Permit No: **951137**

Location of Construction: **10 Stuart St**
 Owner Address: **10 Stuart St- Portland, ME 04103**
 Contractor Name: **Neighborhood Planner Inc**
 Past Use: **1-fam w 2-car garage**
 Proposed Project Description: **reduce the size of garage - by 7 ft**
 Permit Taken By: **L Chase**

CHECK LIST AGAINST ZONING ORDINANCE

Drawing file: 337  C017 / Partial Plot Plan.pdf

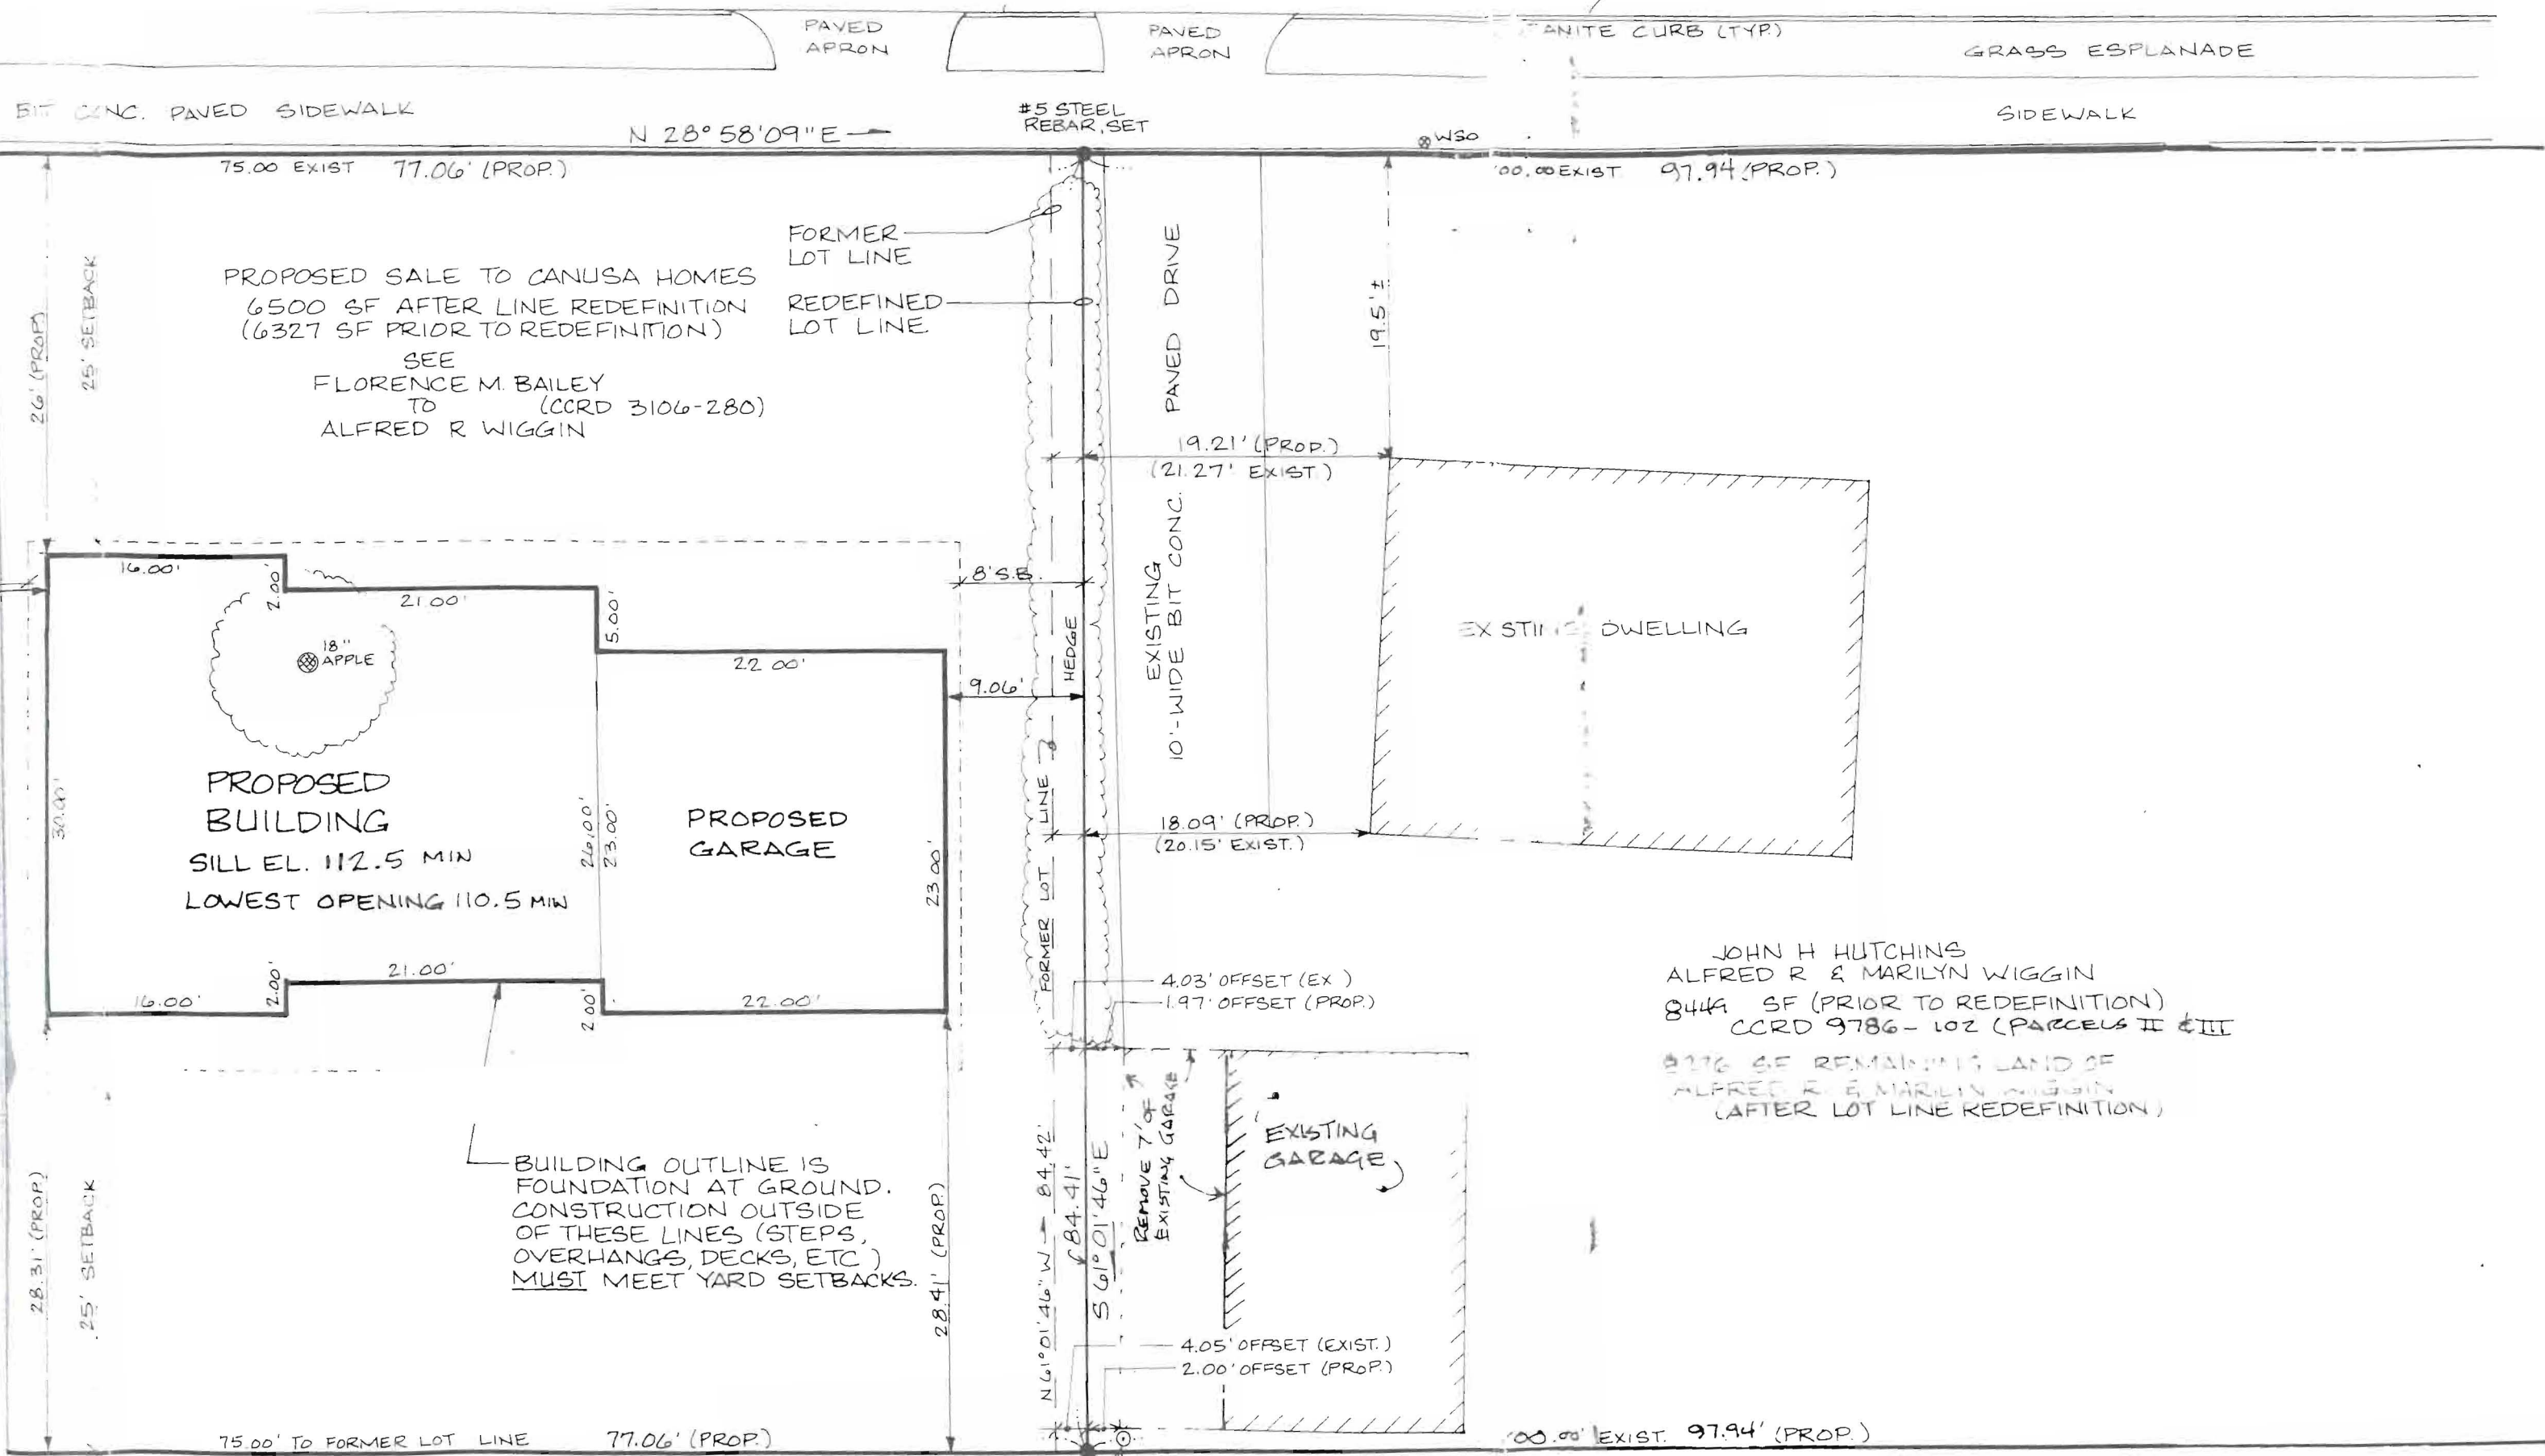
Side Yards - → establishing a new lot line, requires 8' side set back
9' shown

Lot Area - 6,500[#] min 8,276[#] under new division

Width of Lot - 75' req - 97.94' shown (proposed)

Lot Frontage - 50' req 97.94' shown (proposed)
